Application No: A/130/21/PL

Recommendation Report for Planning Permission

LOCATION: 16 Pine Trees Close
Angmering
BN16 4LT

PROPOSAL: Demolition of existing garage, conversion of extension (approved under A/66/21/HH) to 1 No. 2 bed dwelling, provision of 4 parking spaces and cycle/refuse storage. This application is within CIL Zone 2 and is CIL liable as new dwelling.

BLOCK PLAN (SHOWING PROPOSED)
Scale 1:200

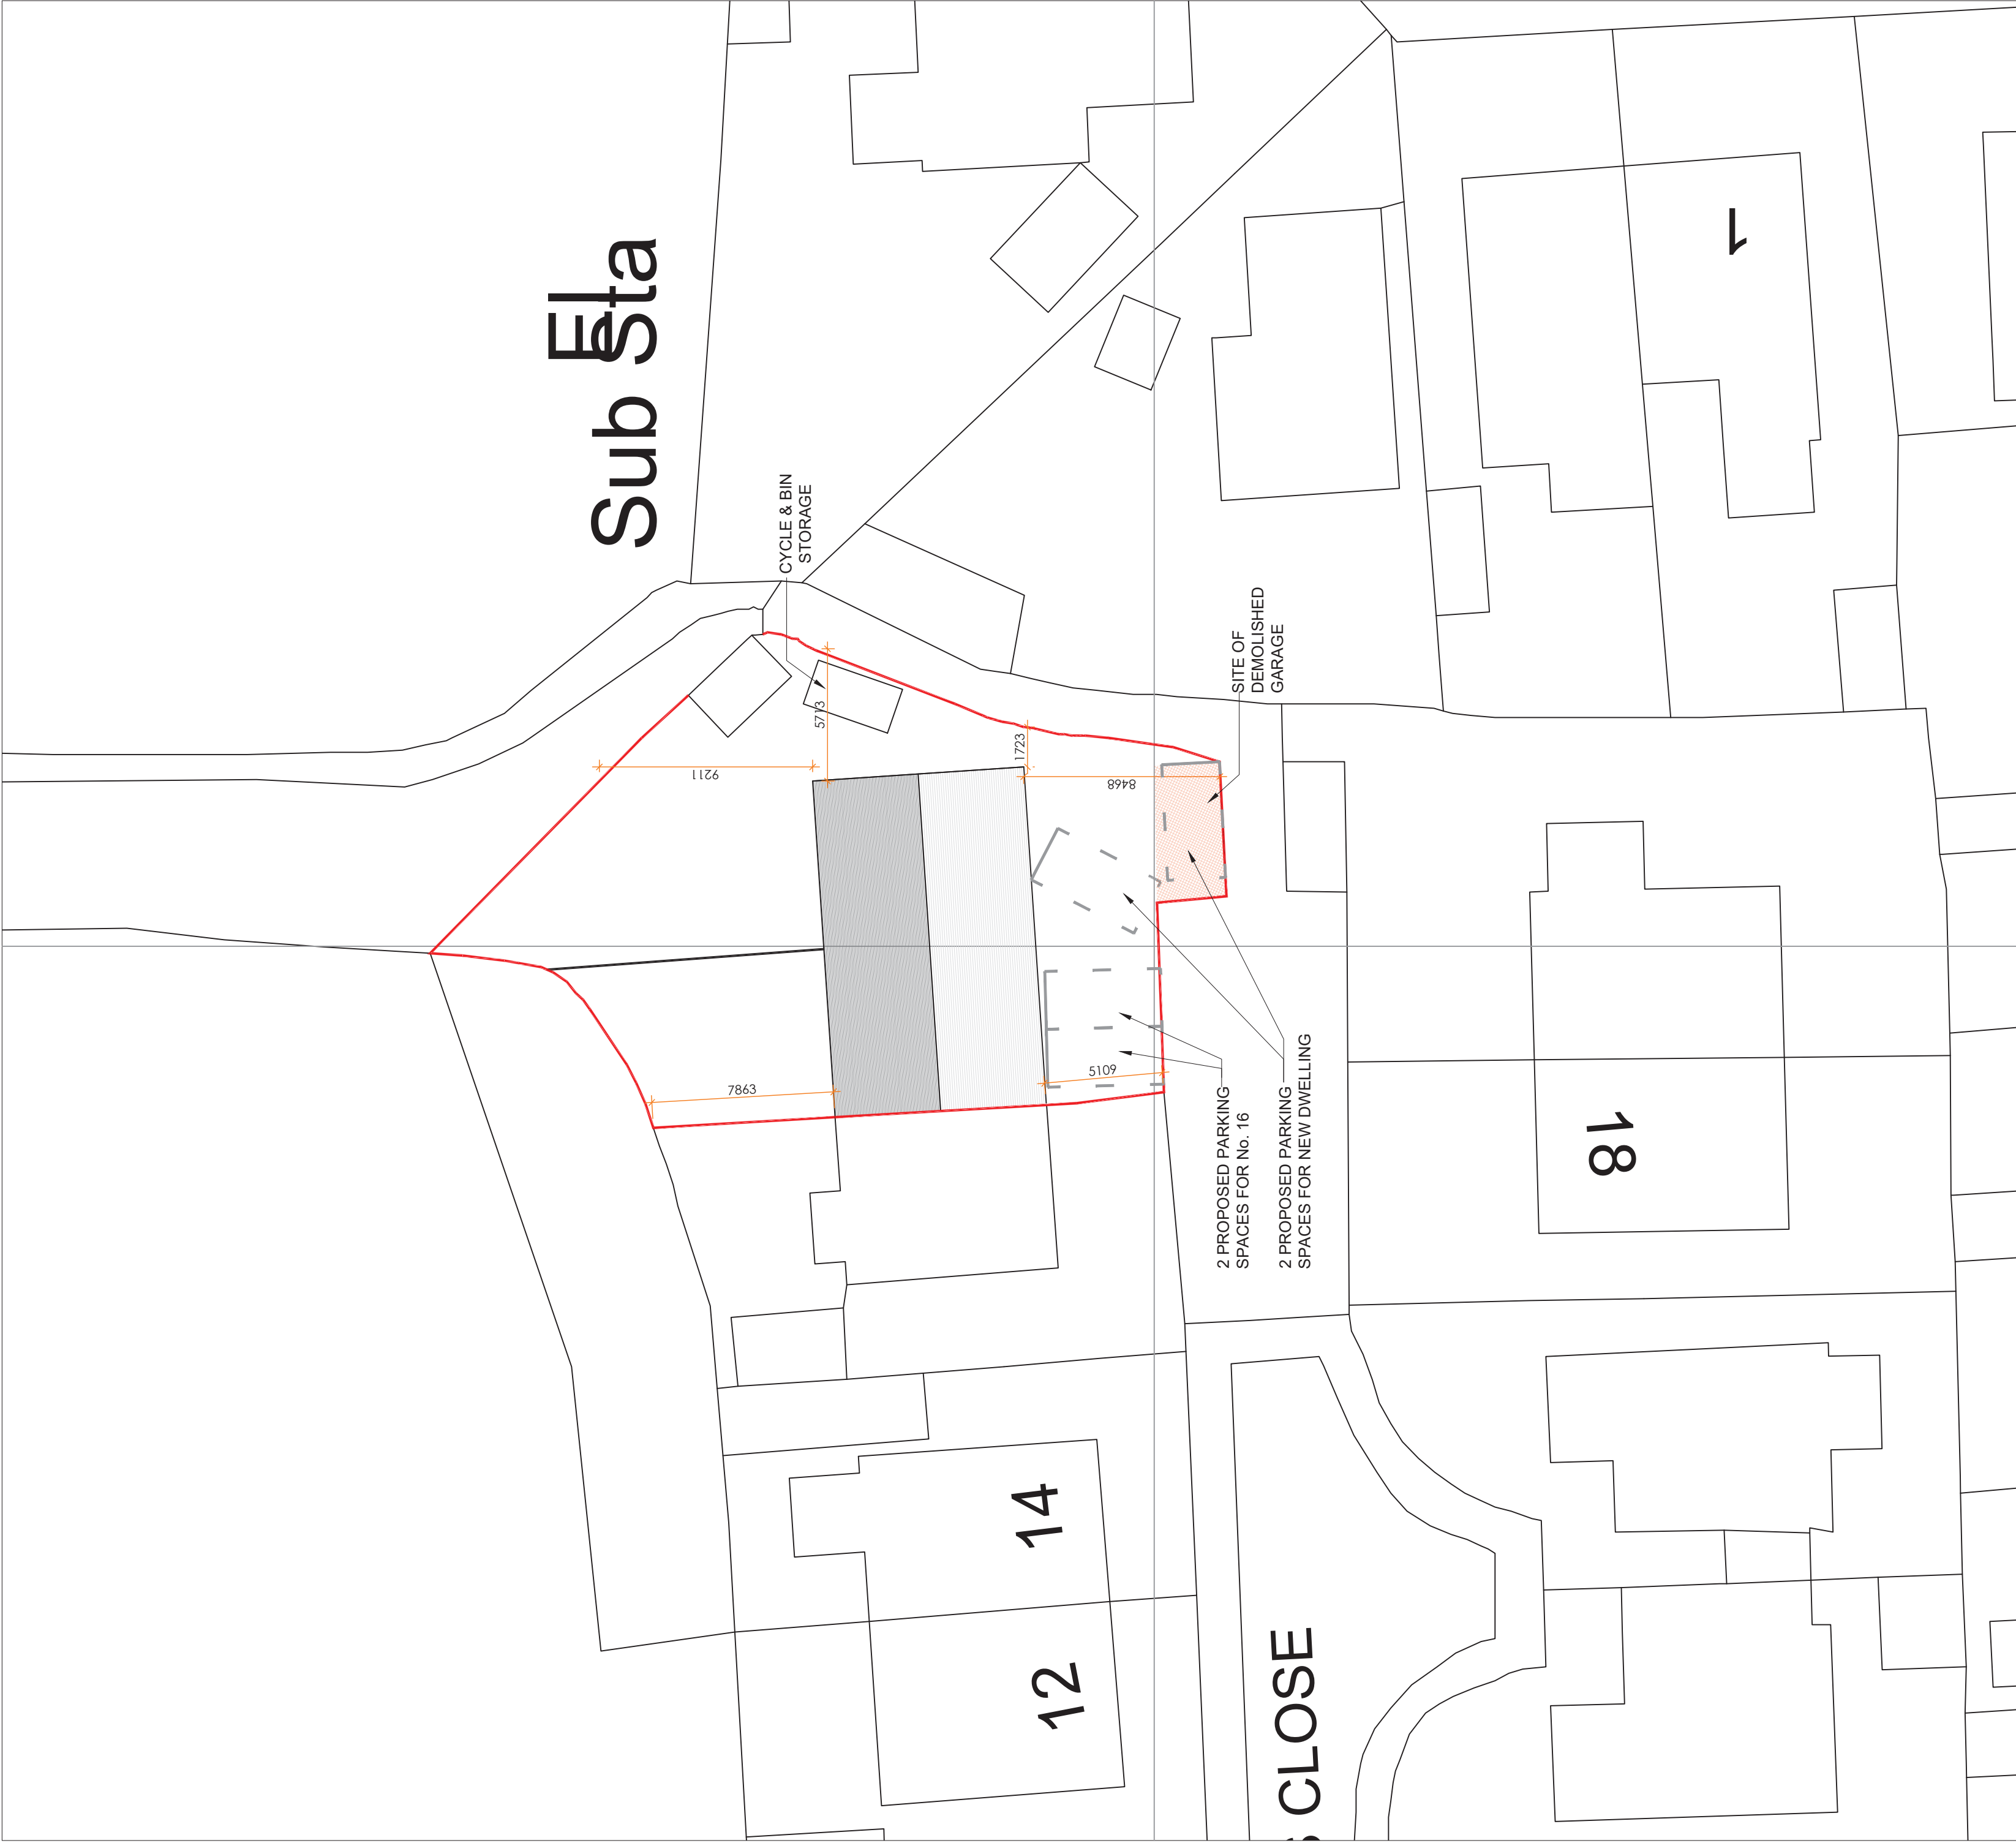
- The provision of 4 parking spaces in front of the adjacent bungalow would be unacceptable.
- The additional vehicle traffic would be unacceptable.
- The narrow footpath next to the site would provide access to the strategic housing site on Dappers Lane.
- The development of a terrace of 3 dwellings would be out of character with the houses in the area.

The Block Plan (Drawing No. 1485-01) shows the single storey extension with a rear garden orientated

north/south that would measure in excess of 10.5 metres in length. The Arun Design Guide specifies that dwellings must have adequate private or share amenity space and provides a figure of 10.5 metres in length. The development complies with Policy D DM1(3) of the Local Plan and the Arun Design Guide in terms of the provision of sufficient private amenity space for the new bungalow.

The single storey extension would have 2 car parking spaces, one on-plot facing the front elevation and the second on the site of the garage which is proposed to be demolished. The provision of 2 car parking spaces is in compliance with the ADC Parking Standards SPD, January 2020 and in accordance with Policy HD8 of the Angmering NP. The existing semi-detached bungalow would be provided with 2 on-plot parking spaces located on the existing hard-standing. A total of 4 parking spaces are to be provided to serve the proposed development in compliance with the Parking Standards SPD. There is sufficient space for vehicles to turn in the site and exit in a forward gear without reversing onto the highway. Cycle parking would be provided in a garden shed in the rear garden, in compliance with Policy T DM1 of the Local Plan and the ADC Parking Standards SPD.

- The provision of 4 parking spaces (2 per dwelling) complies with the ADC Parking Standards SPD.
- The existing driveway would be retained and the garage would be demolished thereby creating sufficient space.
- The existing footpath would be retained and would not be compromised by the proposed development.
- The proposed single storey pitched roof side extension mirrors the previously approved scheme, apart from the sub-division of the plot to create a new dwelling house.
